From: Anita Gardner
Sent: 14 January 2019 11:41
To: Planning.Responses
Subject: FW: LU/314/18/PL Shell Eastfield, Worthing Road, Littlehampton

From: Anita Gardner [mailto:Anita.Gardner@arun.gov.uk]
Sent: Wednesday, 19 December, 2018 14:29
To: [REDACTED]
Subject: LU/314/18/PL Shell Eastfield, Worthing Road, Littlehampton

TITLE : SITE LAYOUT PLAN (1:100) as proposed

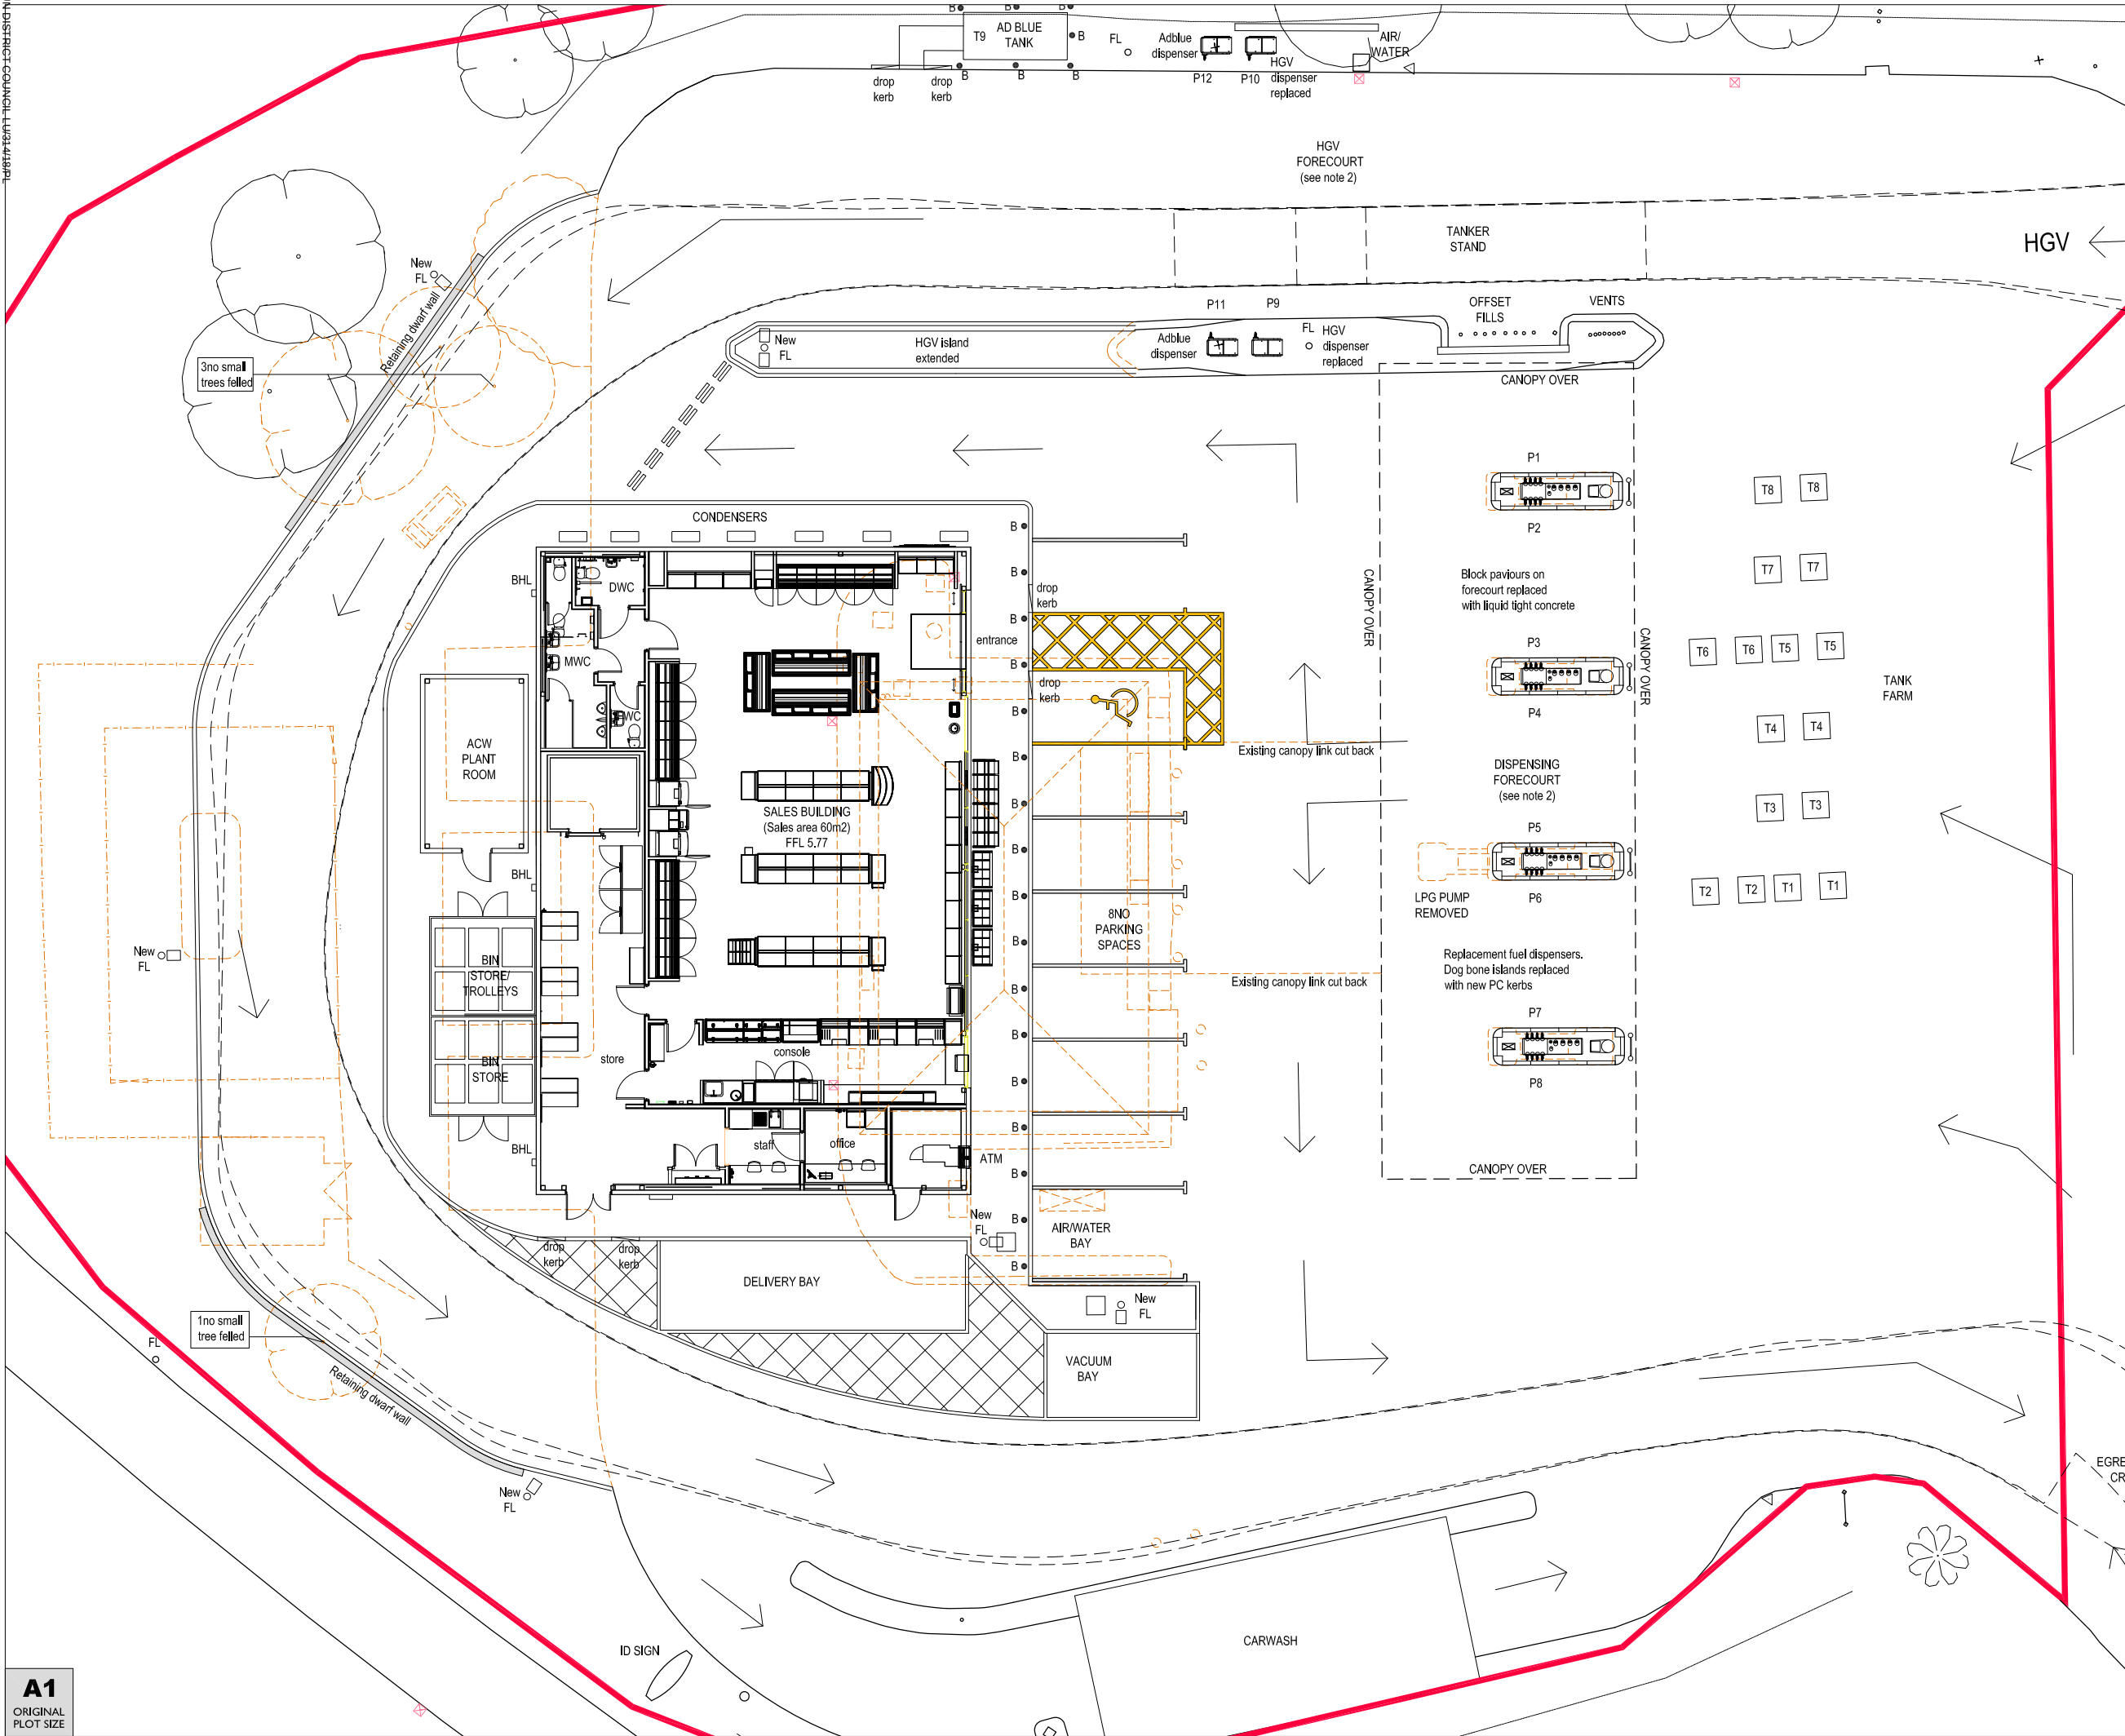
- Will any dedicated staff parking be provided?
- Will bicycle parking be included?

Regarding the Staff parking and Cycle racks. We have limited space on this site, but staff can use the delivery bay area for parking when not in use. With the site being situated on the busy A259 we feel cycle racks would not be used sufficiently to justify them.
